**WELWYN HATFIELD BOROUGH COUNCIL
EXECUTIVE DIRECTOR - PLANNING, PUBLIC PROTECTION AND GOVERNANCE**

Application No: 6/2021/0557/LB
Location: Eight Bells 2 Park Street Hatfield AL9 5AX
Proposal: Installation of non illuminated 1x fascia sign, 1x post mounted sign, 2x painted mural signs, 1x vinyl wall mounted sign, 2x wall mounted signs and 1x lockable poster case and three gold lanterns and two upward facing LED floodlights to facilitate signs
Officer: Ms Kirsty Shirley

Recommendation: Refused

- C ONE x new signwritten mural.
- C1 Size 3.48m x 2.46m H.A.G 4.5m
- C2 Strapline size 3.8m x 252mm. H.A.G 3.3m

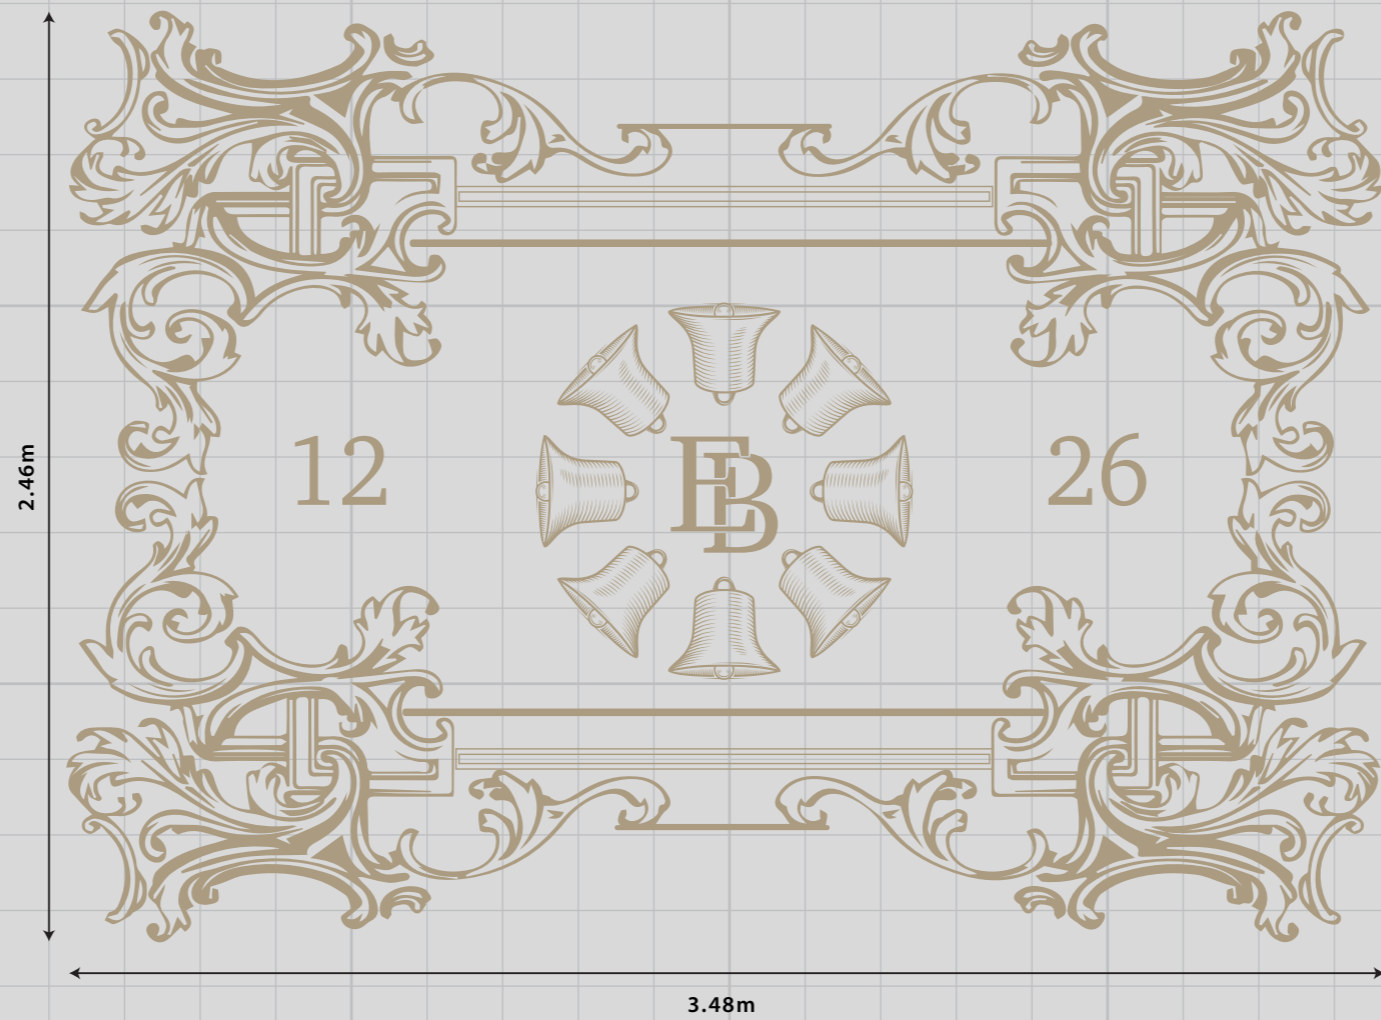
Signs C1 and C2 are proposed to be painted onto the front elevation that faces towards Fore Street. It is considered that the proposed paintings are too large and prominent in this location and detract from the wider area. It is unknown if the proposed 1226 date on proposed sign C1 is accurate and the statement in proposed sign C2 is not considered to be in keeping with the public house or streetscene.

In regards to the proposed replacement of lights (I) to illuminate signs C1 and C2, it is considered that both the existing and proposed lights represent an unattractive modern feature which is out of keeping with the public house. The replacement of the existing lights in this location will continue the incompatible appearance of the lights with the public house.
